CITY OF ALBUQUERQUE

December 22, 2015

**RE: Lot 13
Blue Sky Business Park
Grading and Drainage Plan (Stamp Date 11/3/2015)
Hydrology File: D16D002A5**

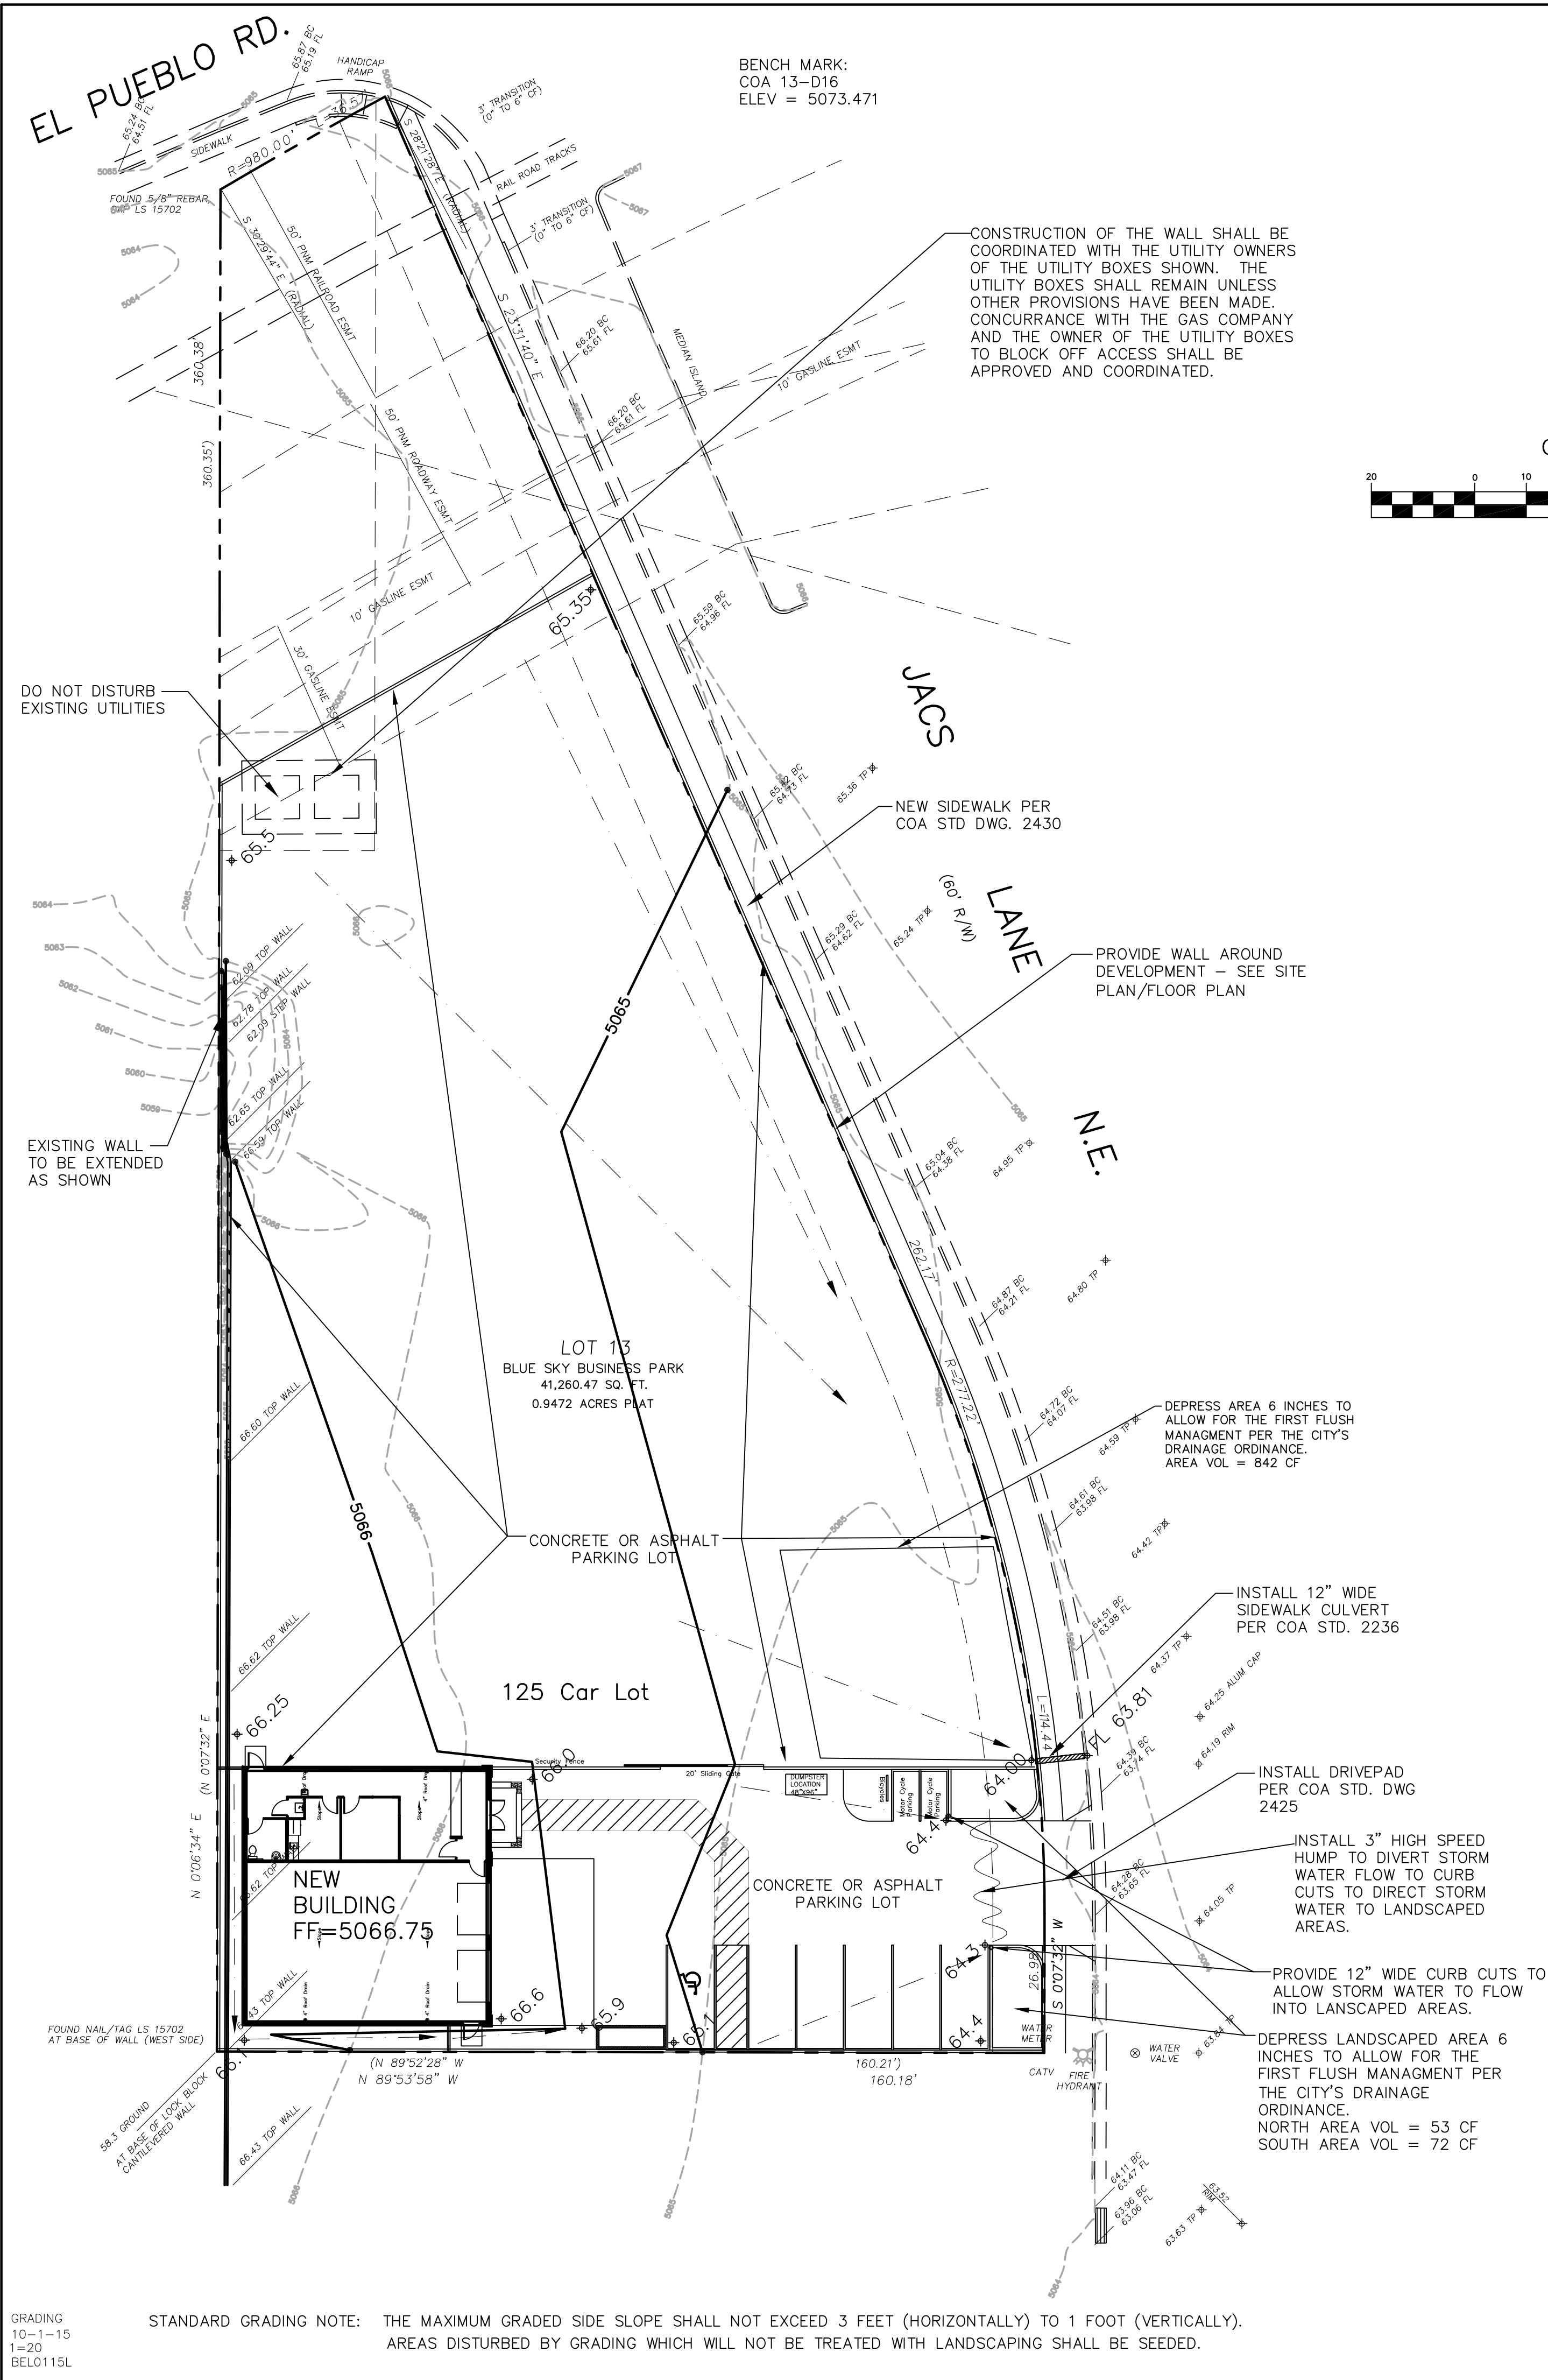
1. The Blue Sky Business Park Grading and Drainage Plan (2005), calculates the allowable discharge from this property (Sub-basin 1-13) including half of Jacs Lane. The drainage calculations for this project should match this format to confirm compliance with the overall plan. See attached Sheets 2 and 3 of the Grading Masterplan for the Development for reference.

2. It appears that the hydrology calculations for the area between the proposed wall and El Pueblo Rd. assume a land treatment "A". This area has been compacted for utility installations, railroad track construction and vacant lot grading, so it should be considered with treatment "C" (which applies to unpaved parking, vacant lots, and soil compacted by human activity).

3. The first flush must be managed on site, per the City's Drainage Ordinance: <https://www.cabq.gov/planning/documents/SignificantDrainageOrdinanceChanges0414.pdf>, effective May 2014. The first flush volume is equal to the impervious surface area times 0.44 inches (minus 0.1 inches for initial abstraction). Landscaped areas may be depressed and used for first flush volume routing.

4. Roof flows (to the most practicable extent) must be routed through a first flush pond.

5. Show the limits of paving for the proposed car lot.
6. The perimeter wall that is proposed is shown conflicting with the utility boxes called out to remain. Furthermore, there will need to be concurrence from the Gas Company and the owner of the utility boxes to block off access, to place a wall within the gas easement, potentially over existing gas and other utility lines.
